CITY OF PORTLAND

January 21, 2004

RE: 59 Myrtle Street – 026-K-002 – R-6 Residential Zone - permit application #03-1519

FLOOR PLAN

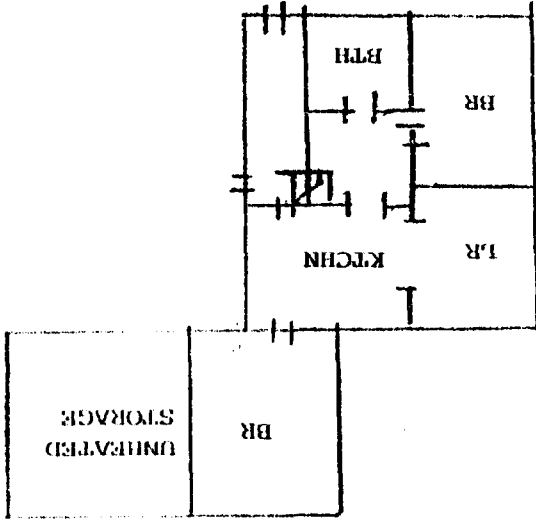
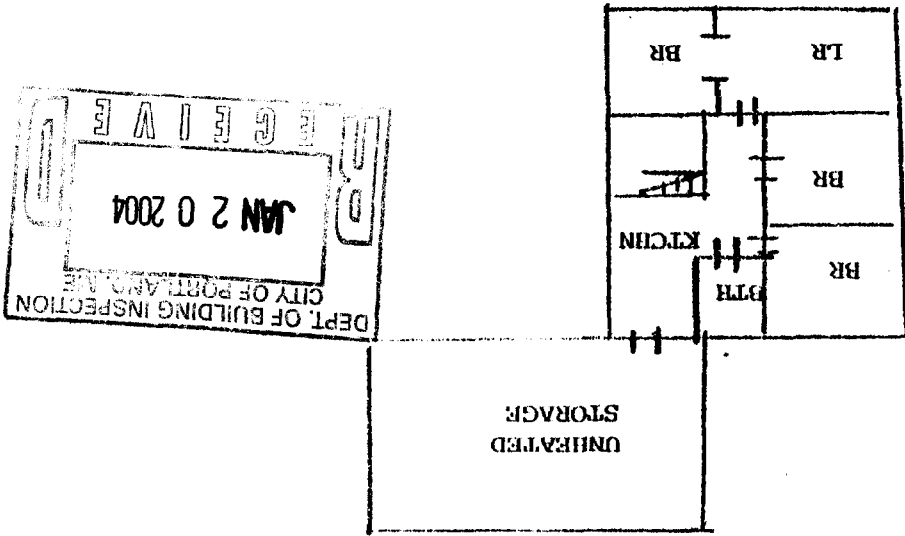
Section 14-136 requires minimum sizes for a newly created dwelling units. Your submitted plans are not shown to be to scale, so I can not determine whether you would be meeting this requirement. That same section states that no existing unit be reduced to less than 1,000 square feet in size. Again, your submitted plans are not shown to be to scale, so I can not determine whether you would be meeting this requirement.

PLOT PLAN

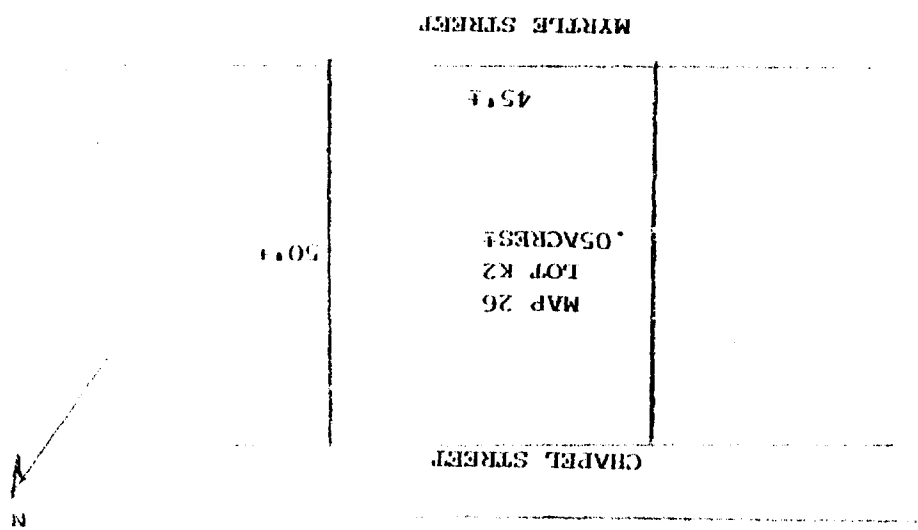
Section 14-139 of the R-6 zone requires 1,000 square feet of land area per dwelling unit, or a minimum of 3,000 square feet of total land area. Your lot per the Assessor's records show a lot size of 2,381 square feet.

If you were to gain approvals for an additional unit, the site plan section of the ordinance, requires a site plan review. You would also be required to show leases to the adjoining parking spaces that you say are available to you.
